January 4, 2024

RE: Residential Building Permit Intake Combine Notes – Intake Screening # 2311-047

Parcel Number: 362550-0210
Rene Lund – Fire Restoration and Addition
8520 SE 82nd ST
Mercer Island, WA 98040

A-101

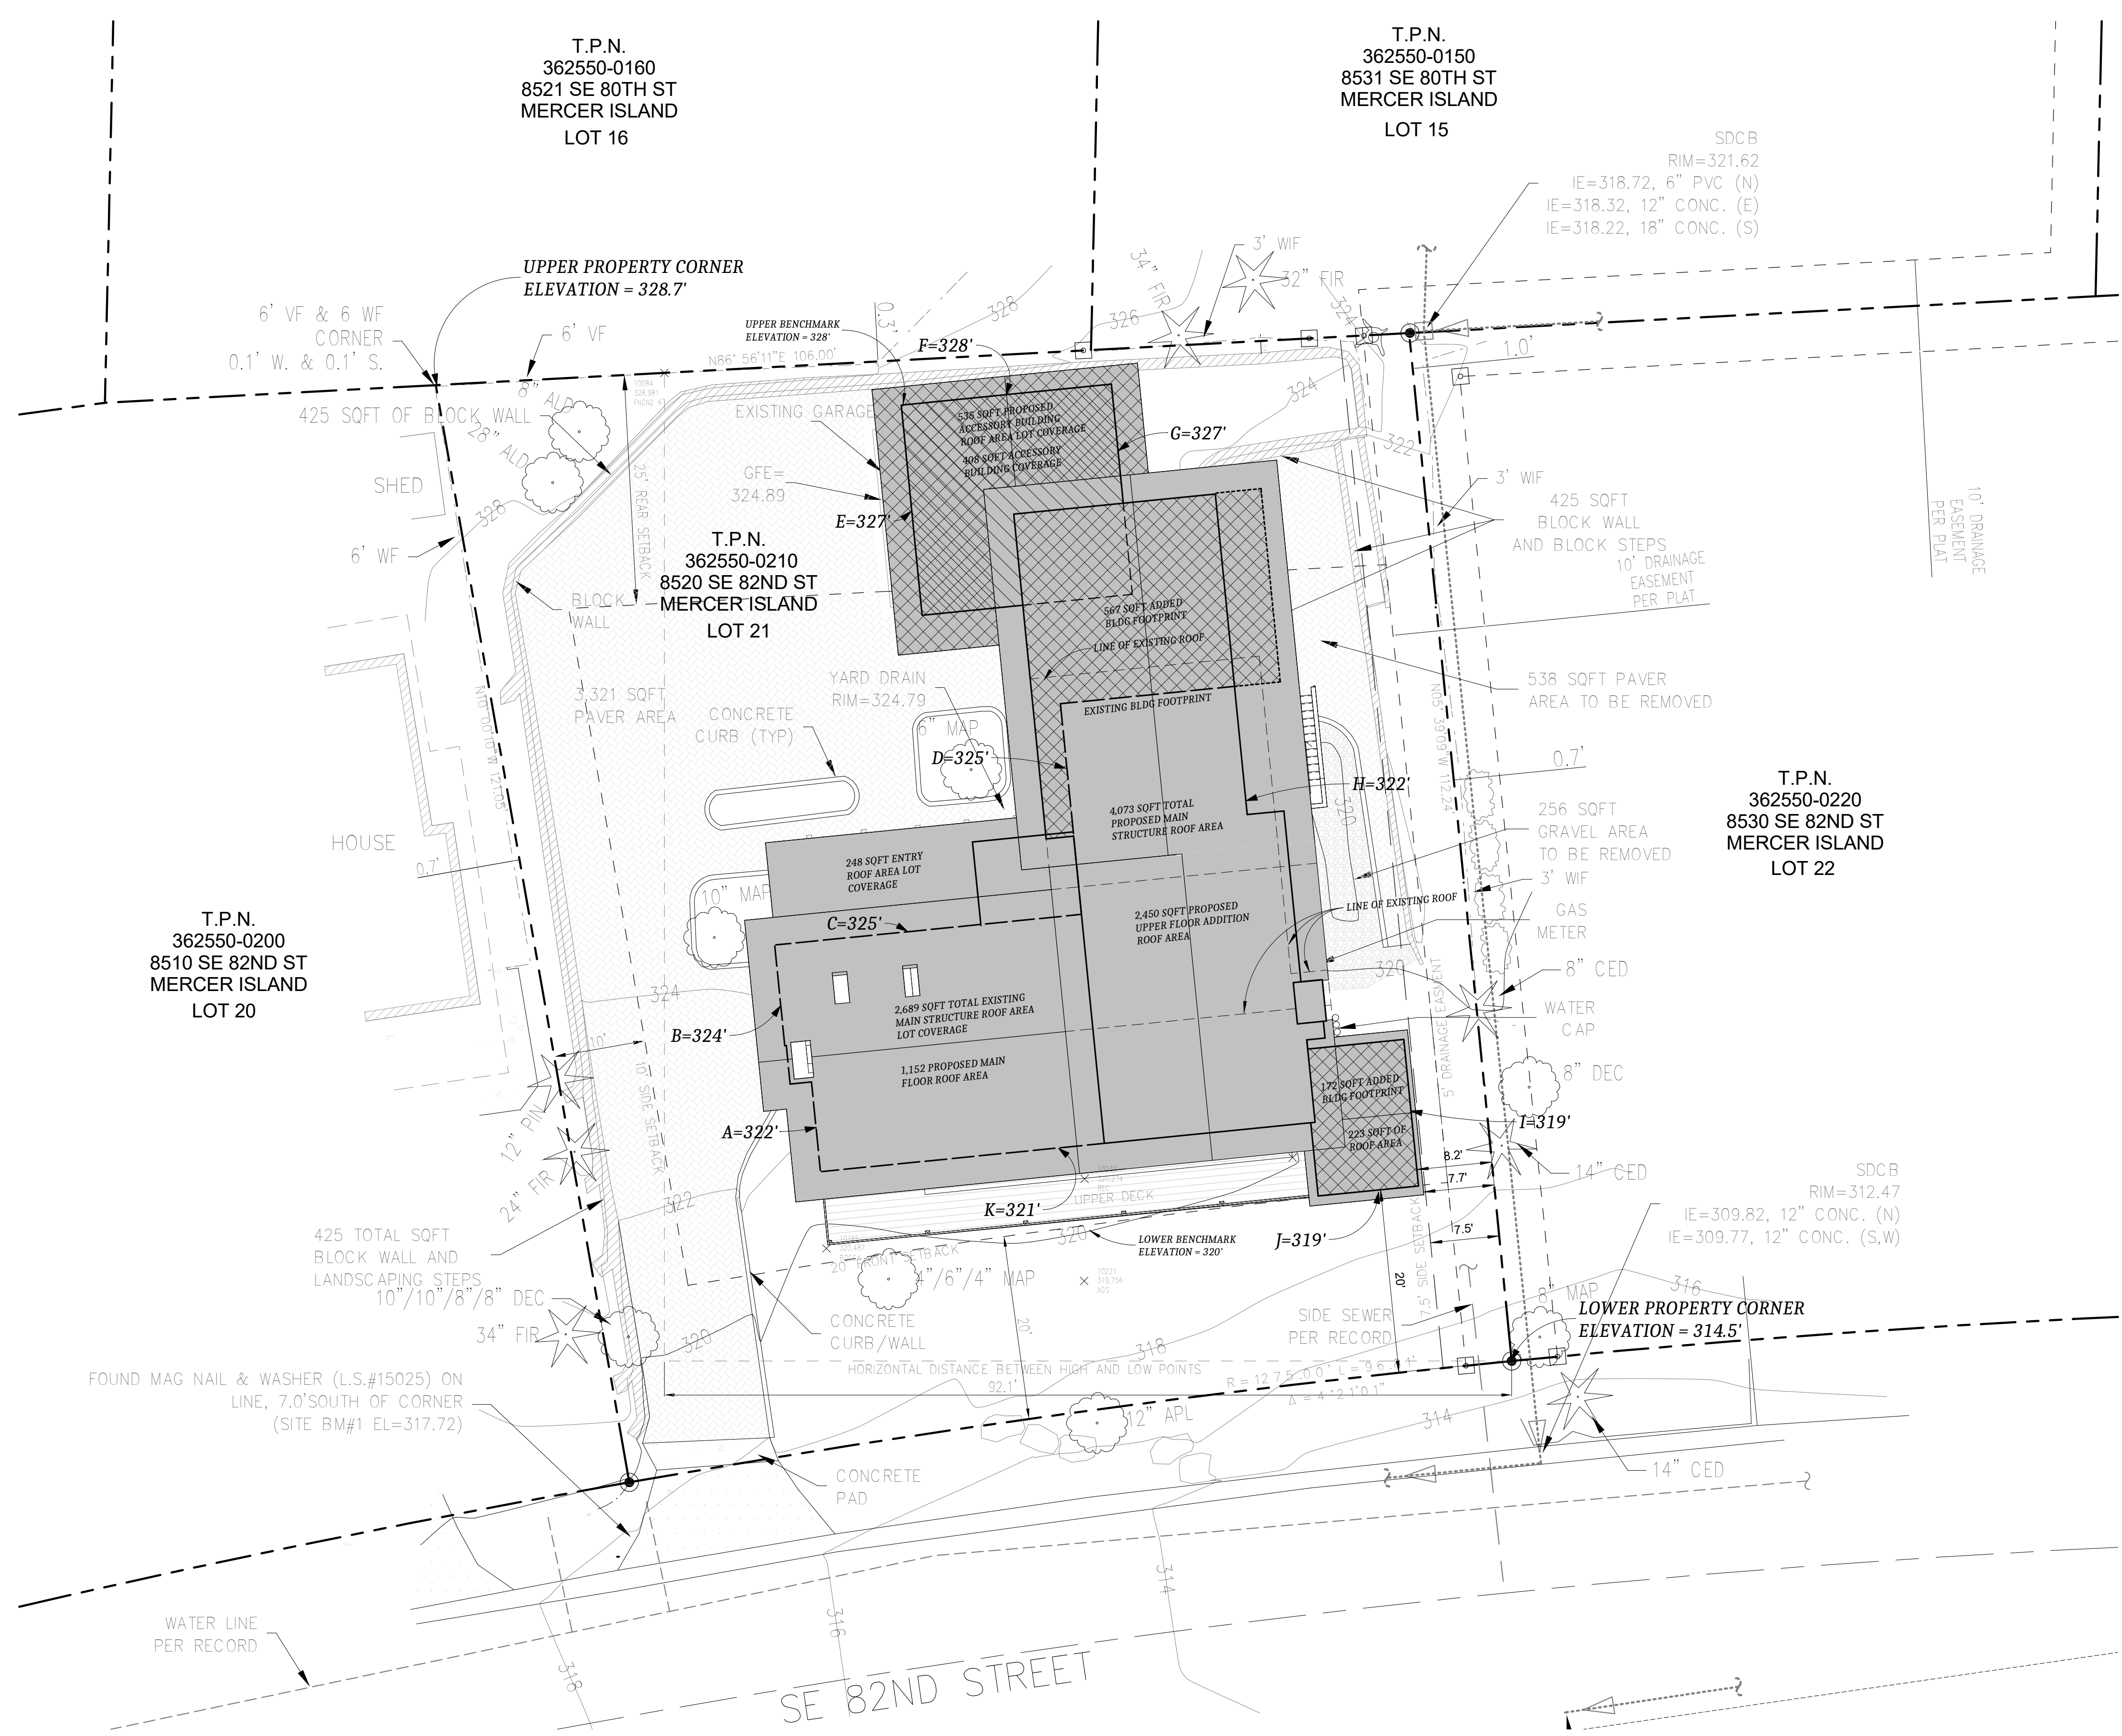
3. Planning Division
 - a. The east side set back was corrected from 5' to 7.5' to reflect conformance to MICC 19.02.020(C)(1)(c)(iii).
 - b. The addition footprint and roof overhang on the east side were redesigned to conform to within the correct set back.

4. City Arborist - Trees
 - a. The site plan was updated to show all current trees per the topographic survey pending a tree inventory report to be generated by a qualified Arborist when one becomes available. It is determined that there will be no affected trees either for removal or requiring protection for this project.

MAIN LEVEL SHEAR WALL PLAN
SCALE 1:64

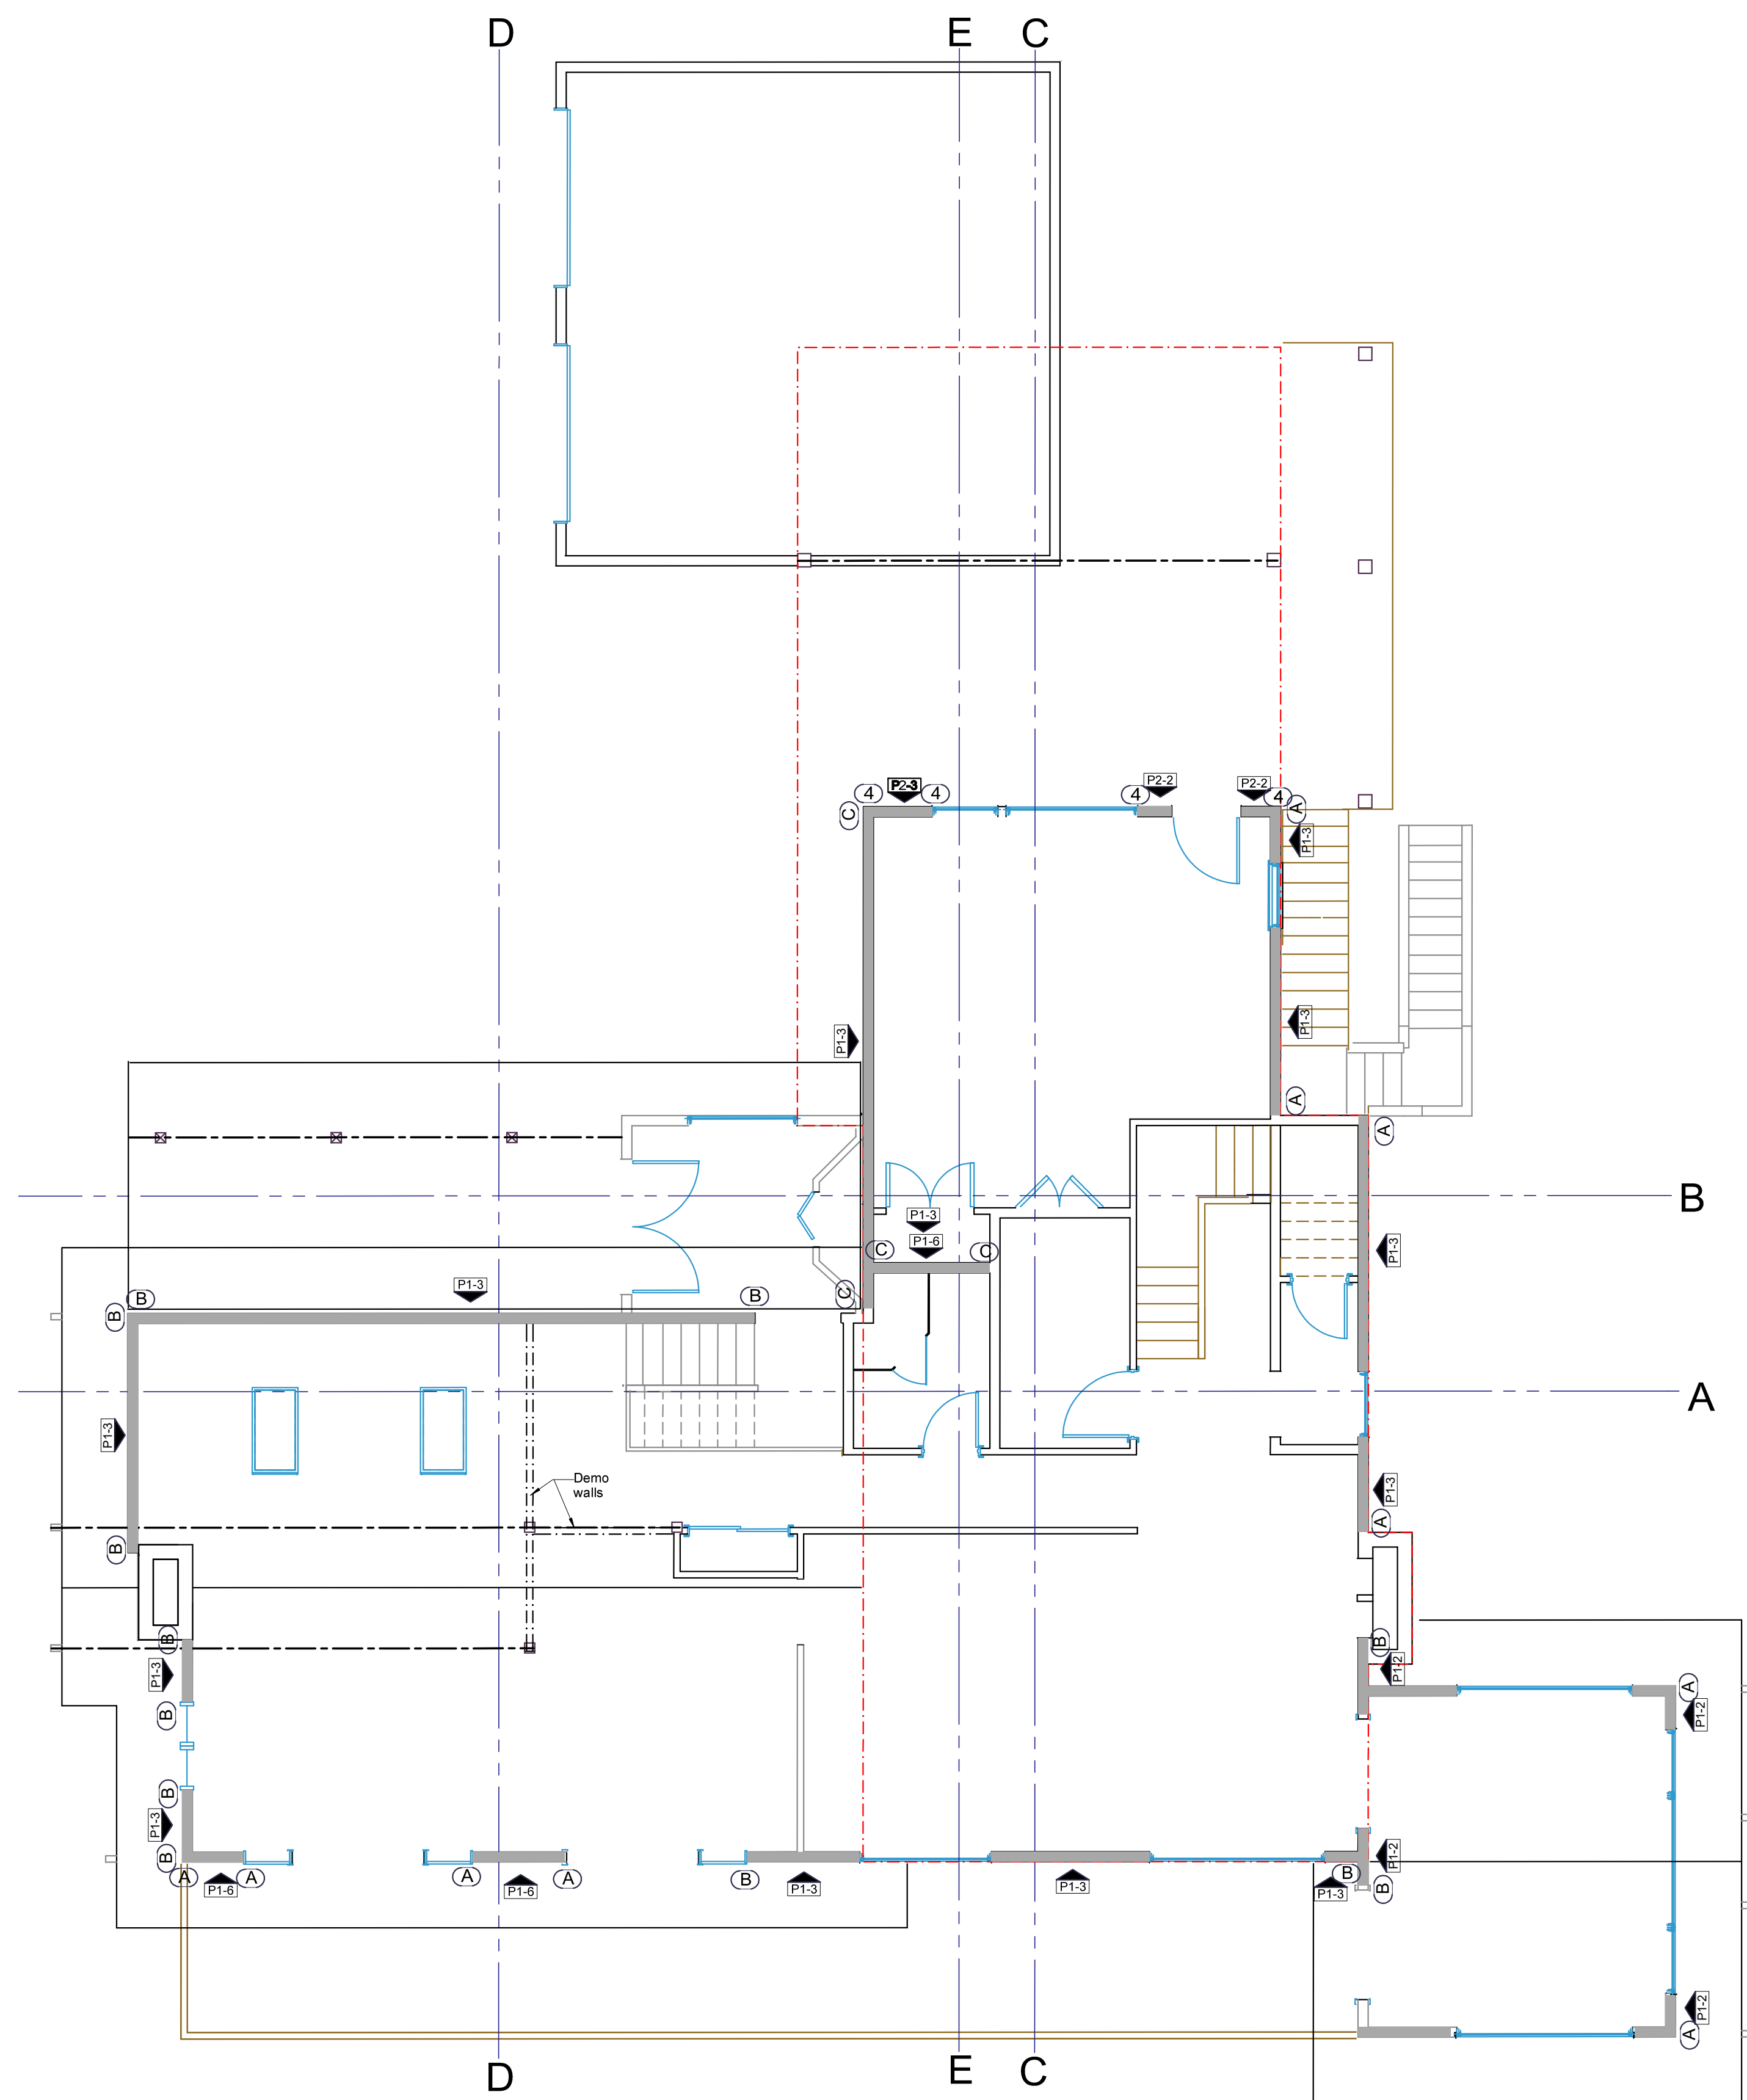
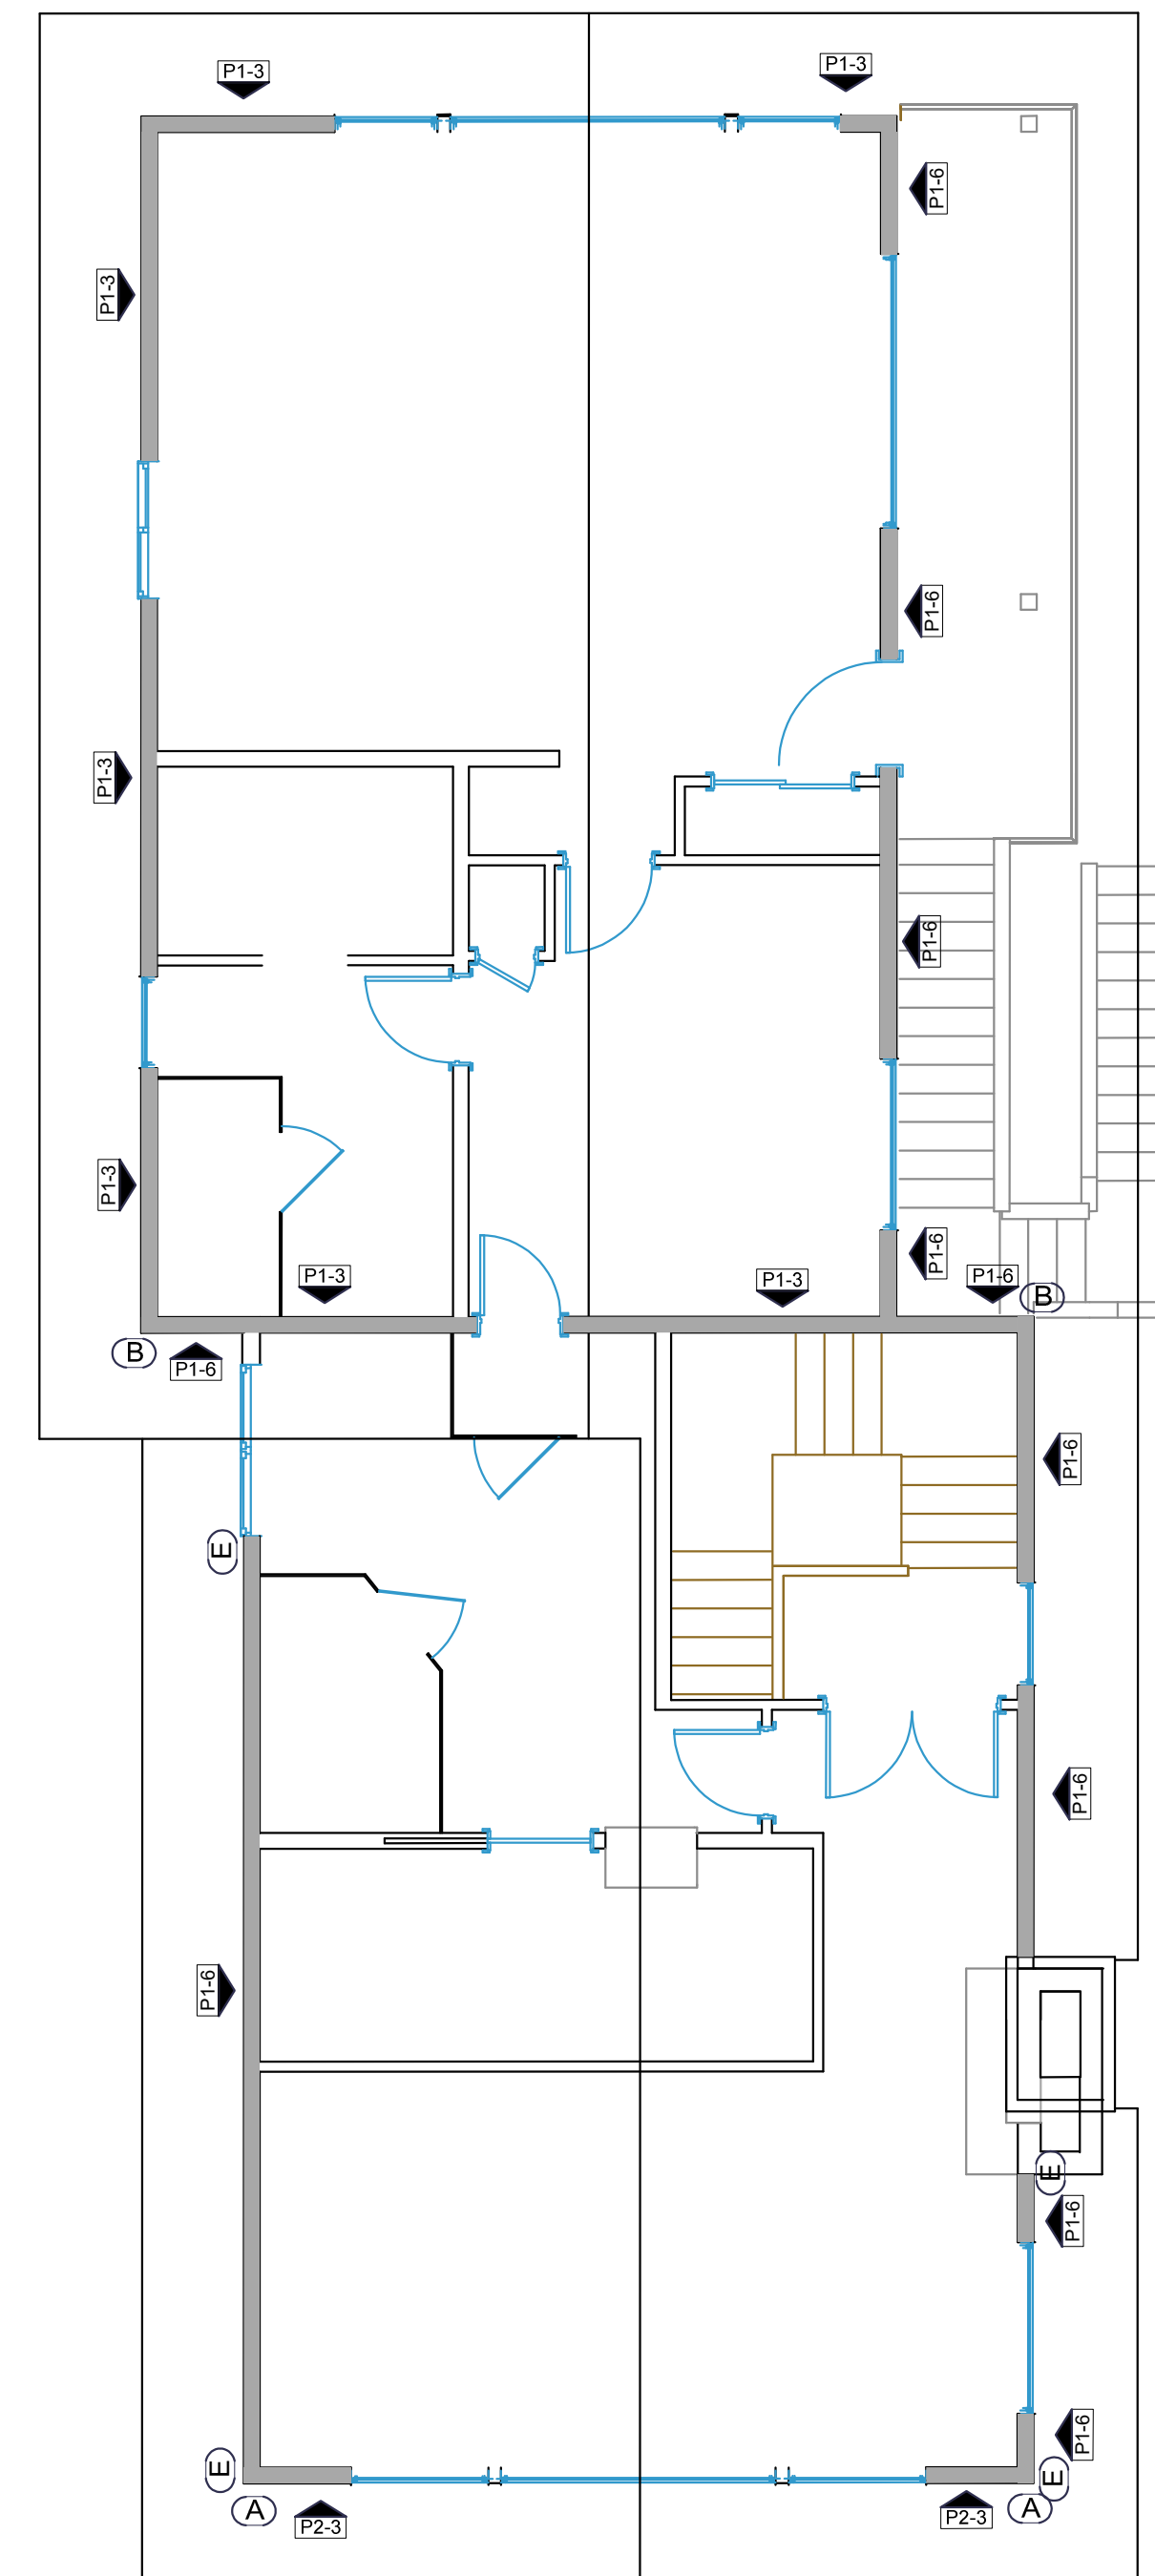
2. Building Division
 - a. The structural design was updated to reflect the required lateral design corrections for the adequate wind speed as required per the intake comments.
